Rustington Parish Council

Date: 12 October 2017

R/202/17/TEL - Prior notification for installation of a 15 metre monopole supporting 3 No. antennas, 1 No. equipment cabinet and ancillary development. Remove existing 3 No. cabinets and 2 No. antennas - Adopted grass verge, Claigmar Road, Rustington

Drawing Title: PROPOSED SITE ELEVATION

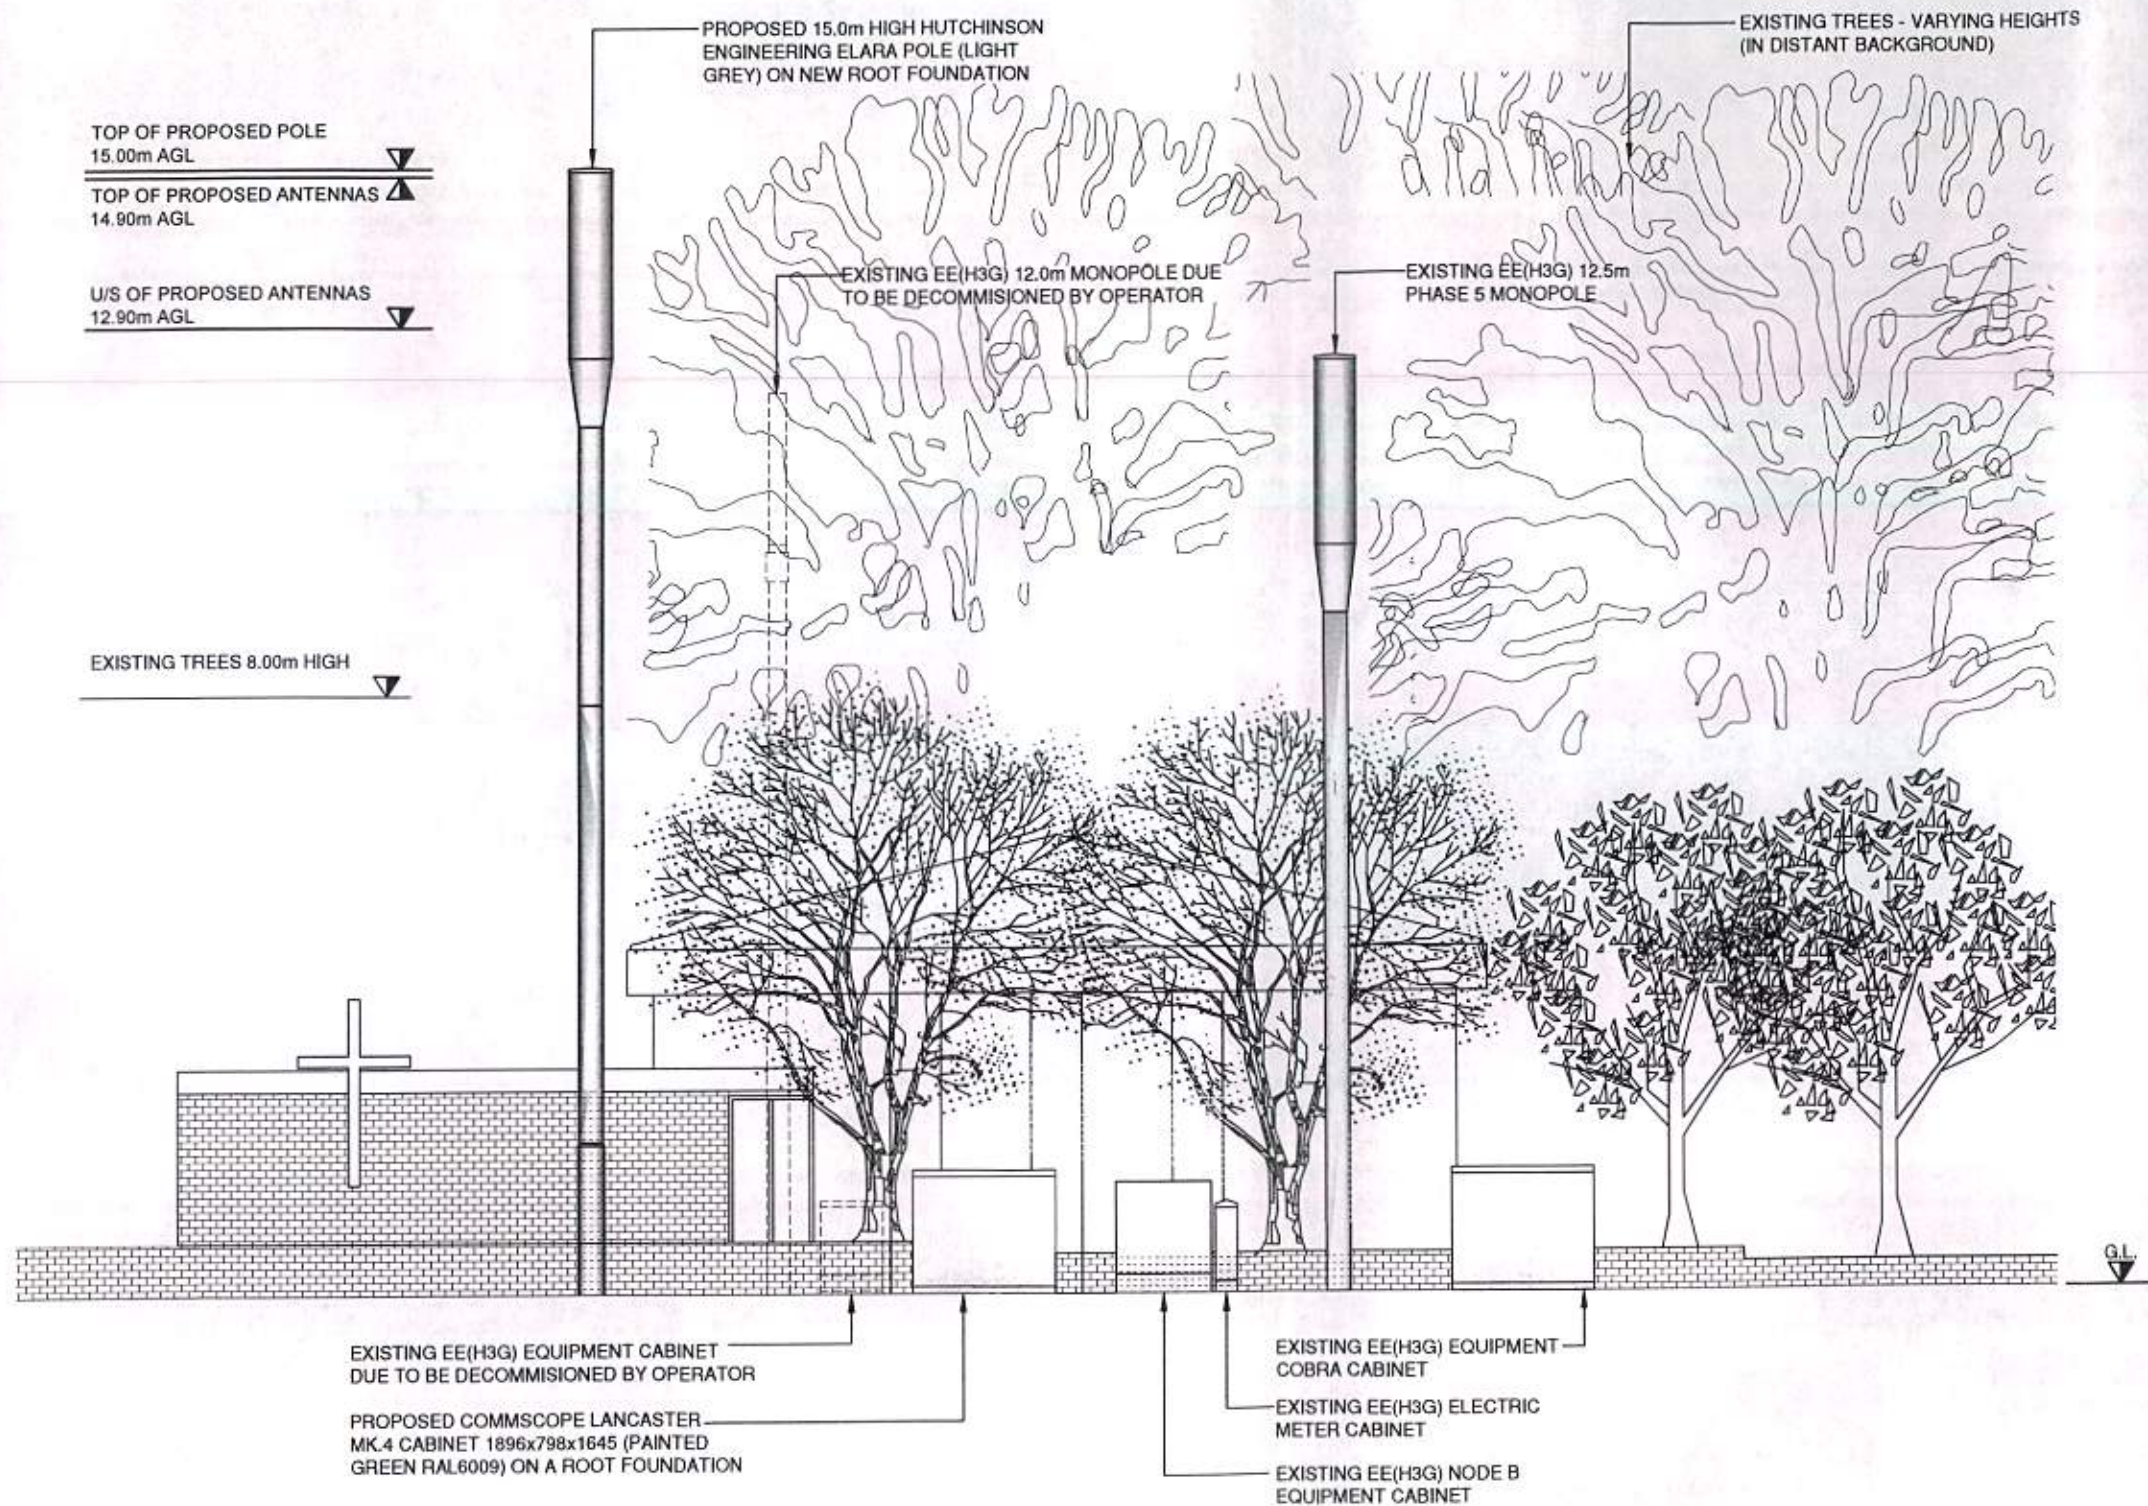
- (i) That the installation of the proposed monopole and associated equipment should, if practicably possible, take place after the EE redundant mast, antenna and cabinet have been removed, as confirmed in the attached email correspondence with EE Public Affairs, with this location being used instead of the proposed location

- (ii) That, if Option (i) above is not possible, the proposed location for the monopole and associated equipment should be re-located in a northerly direction, as indicated in the attached photograph

- (iii) That, if practicably possible, the monopole should be one of the 'tree' design poles. This would be preferable, taking account of the fact that Rustington is an award winning South and South East in Bloom, Britain in Bloom and Europe in Bloom Village, renowned for its floral displays and pleasant aesthetic appearance, with all street furniture being tastefully selected to compliment the ambiance of the surrounding area, and all of which are maintained to a very high standard.
